**Comments on Environmental Statement – Chapter 5: Project Description – Draft
March 2023 – issued to the LPA on 28 April 23**

FIGURE 5.2.1d

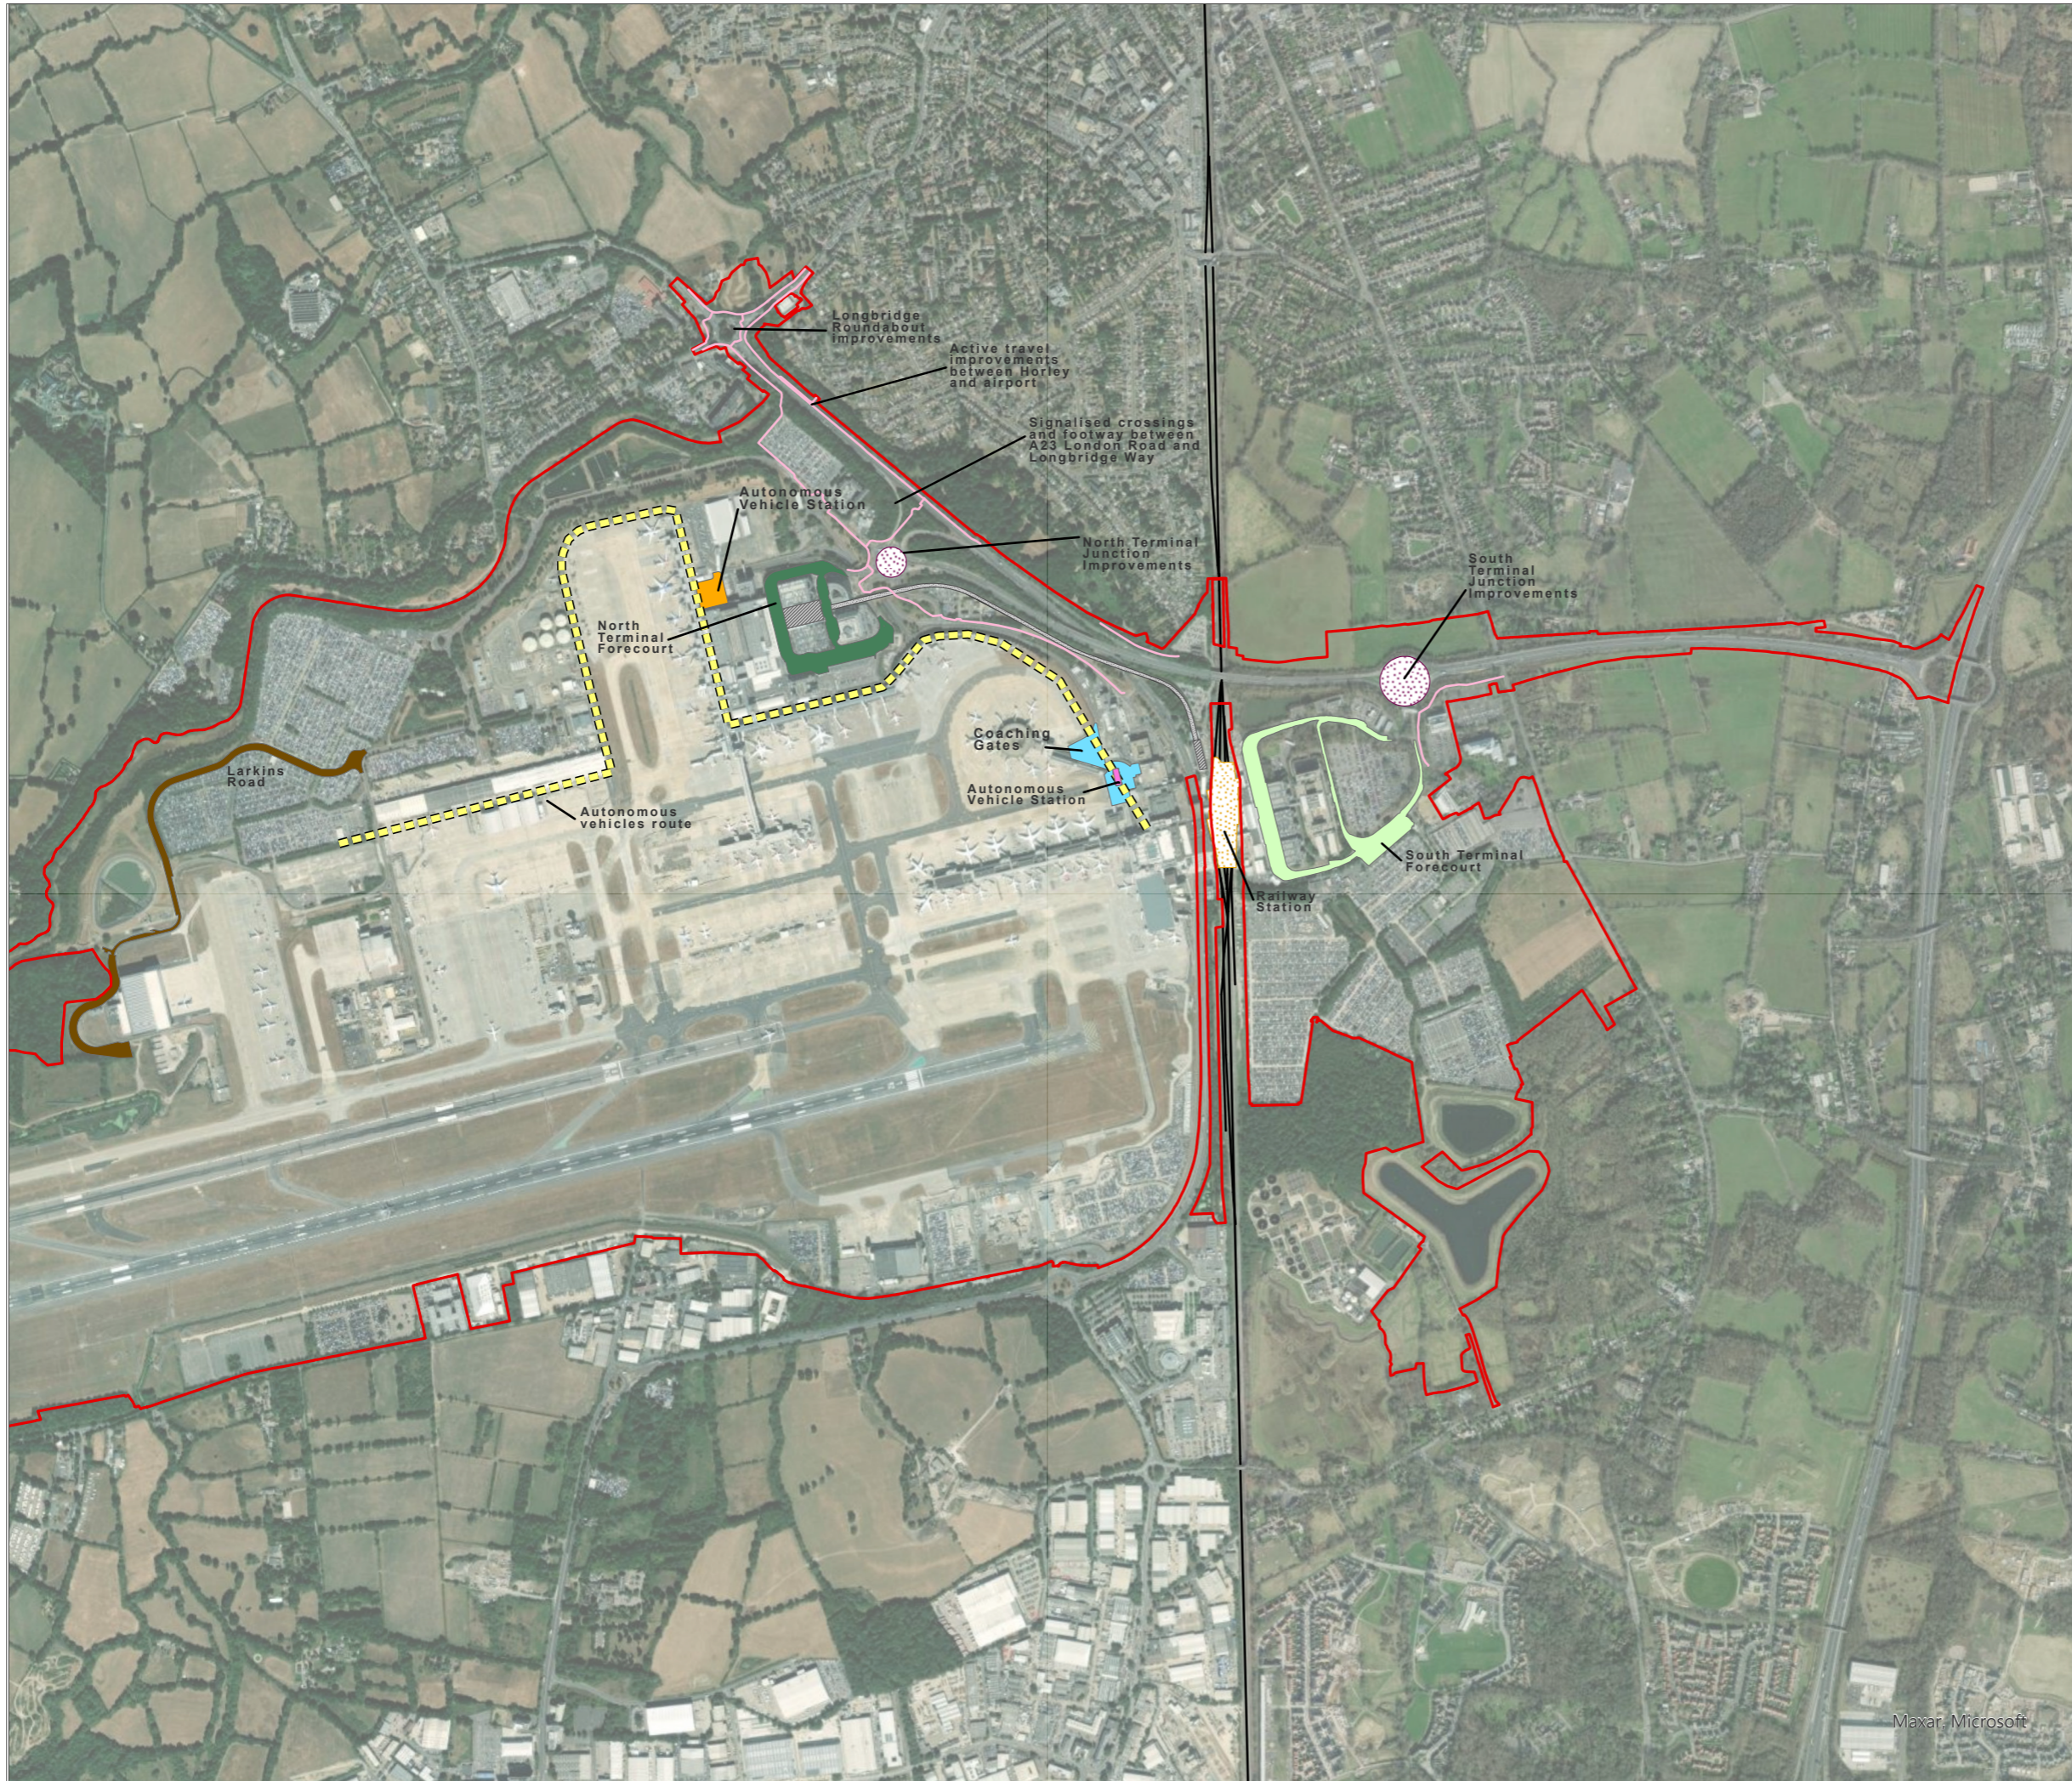
Fig 5.2.d	Surface access changes are not well illustrated and misleading. Road proposals lack any detail. On airport routes shown are hard to understand and not well cross referenced to the text

FIGURE 5.2.1e

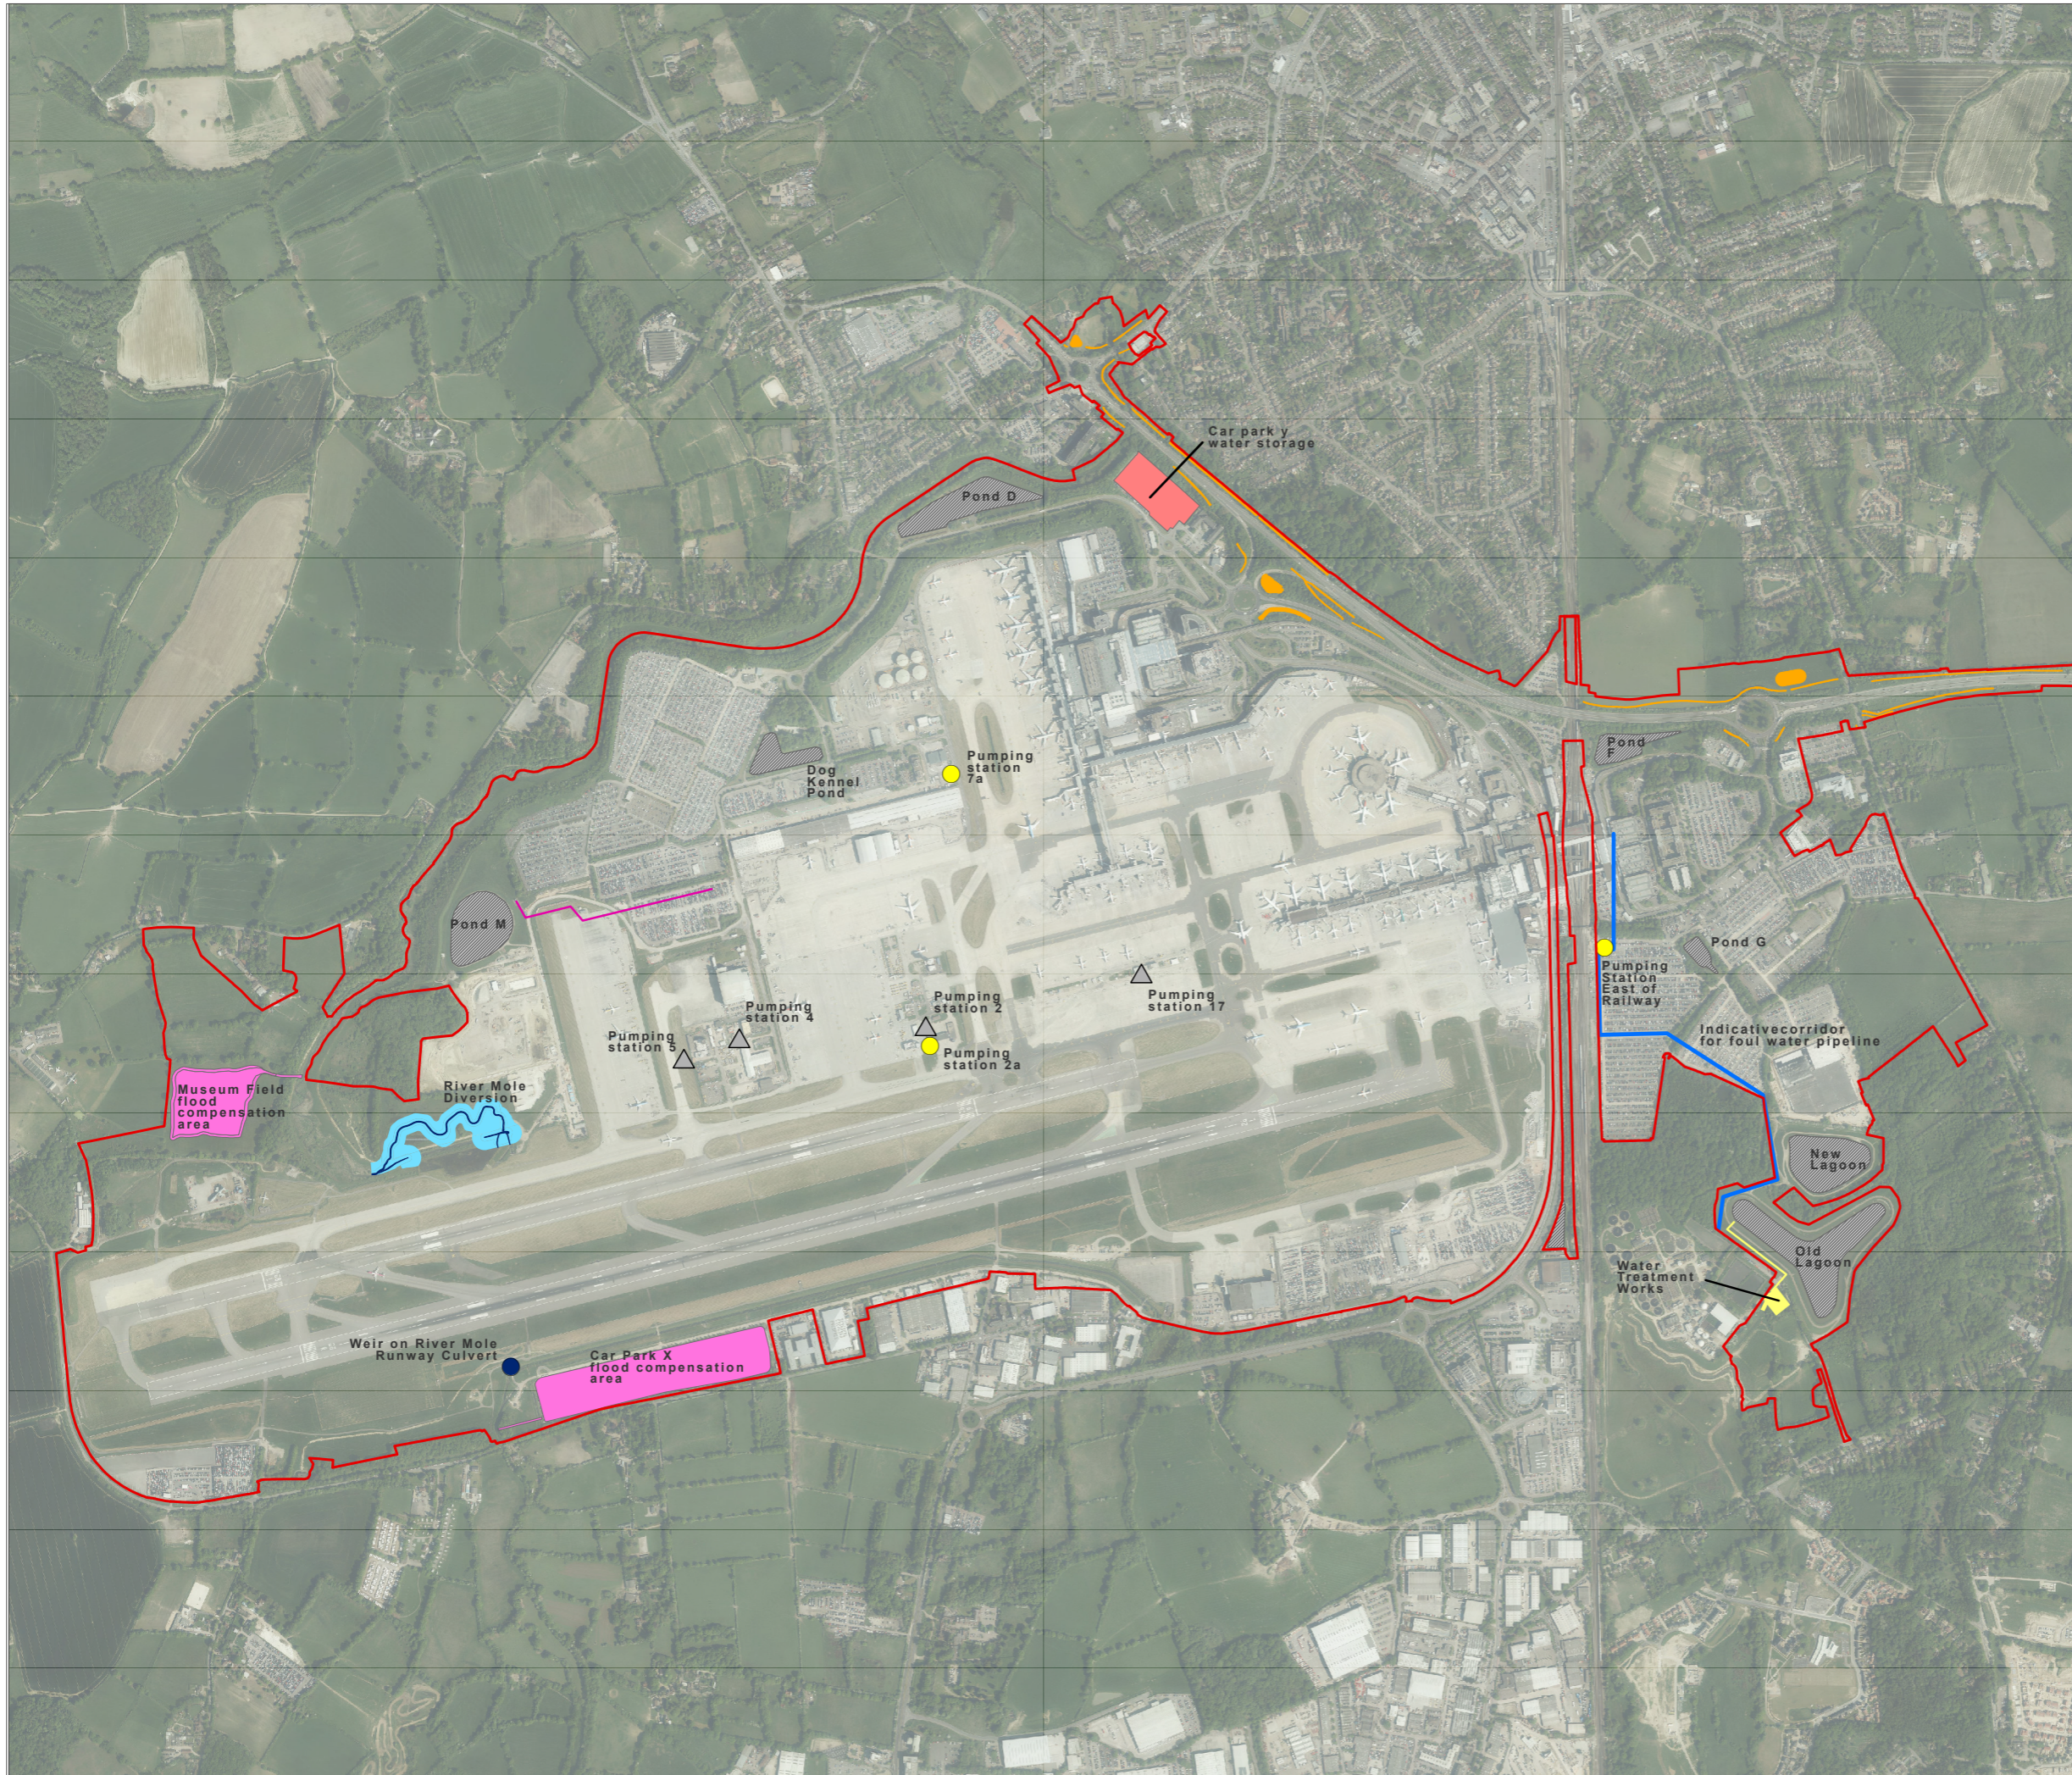
5.2.87, 5.2.94	Active travel measures are not clear. Where are these they are not shown on any plans?
5.2.103	It is difficult to understand the water management proposals from the information provided, again these are not clearly labelled on fig 5.2.1e

ORIENTATION 	DRAWING NO. FIGURE 5.2.1h	REVISION For ES Issue
	DRAWN BY MS	PM / CHECKED BY KC

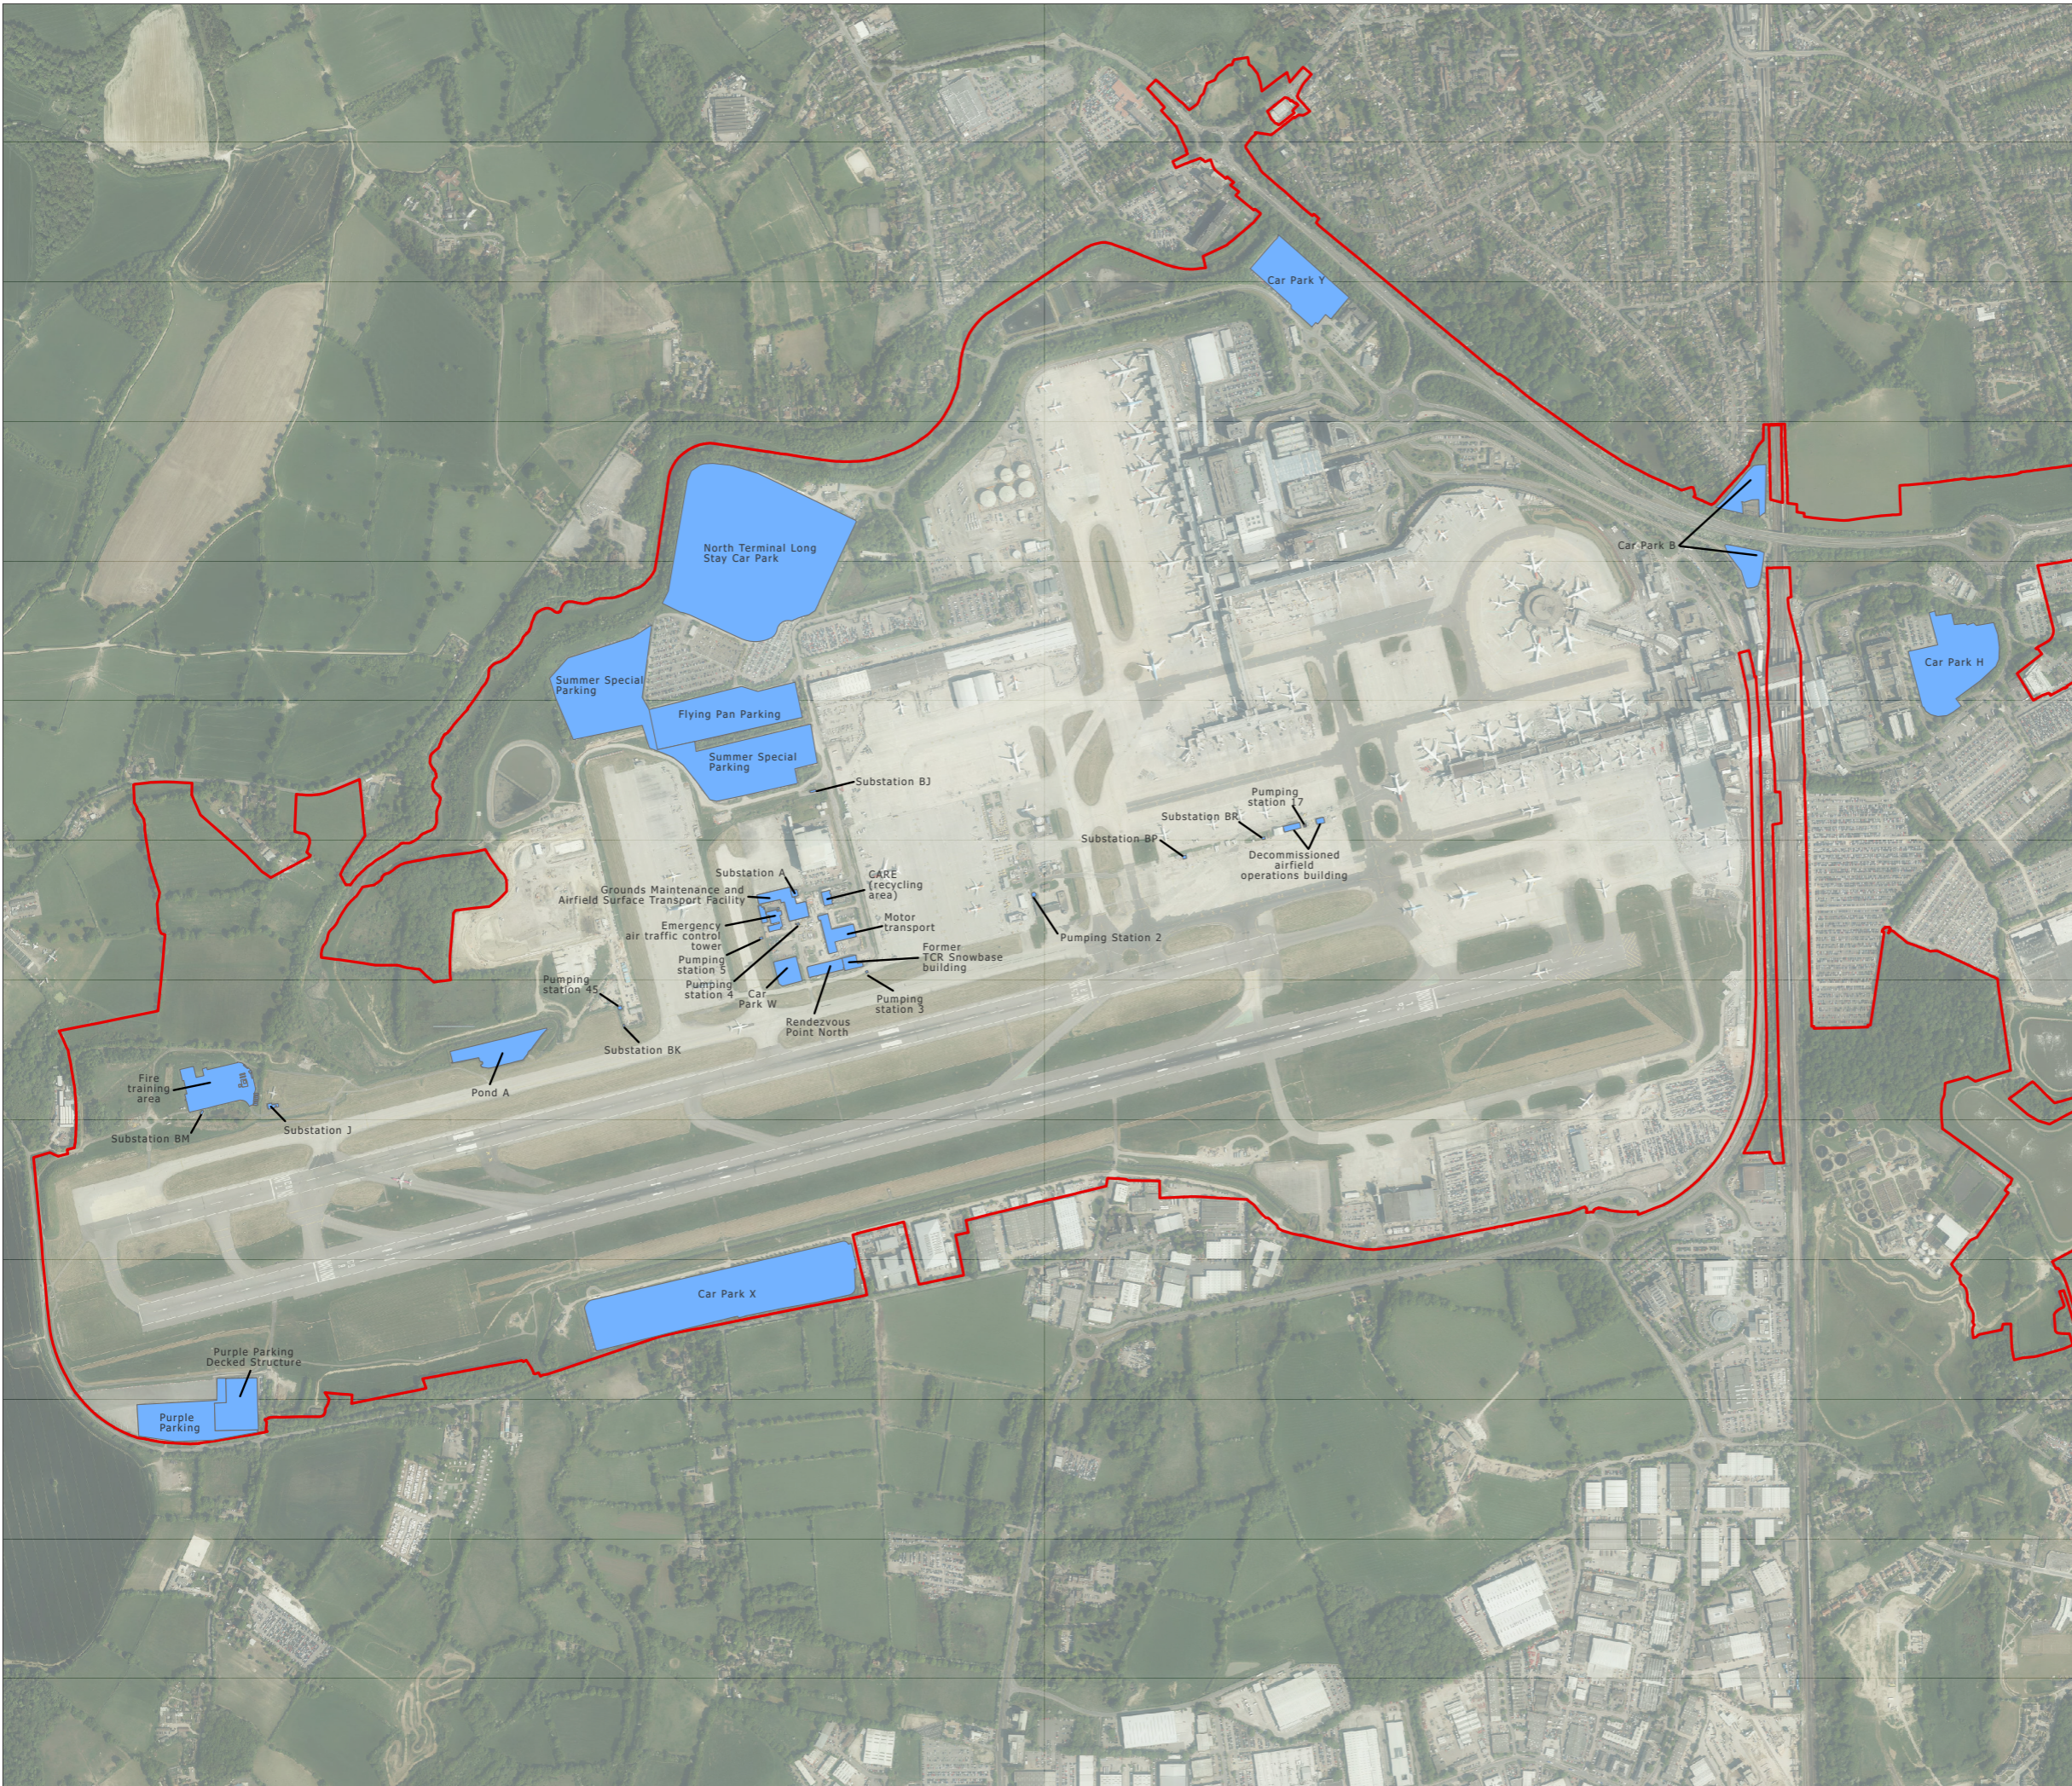
5.2.37, 5.2.39, 5.2.41, 5.2.42, 5.2.44, 5.2.48	It is not clear where these facilities current are located, although there does appear to be plan 5.2.1h it would be helpful if this could be cross referenced in the text of the document to aid understanding of the proposal.
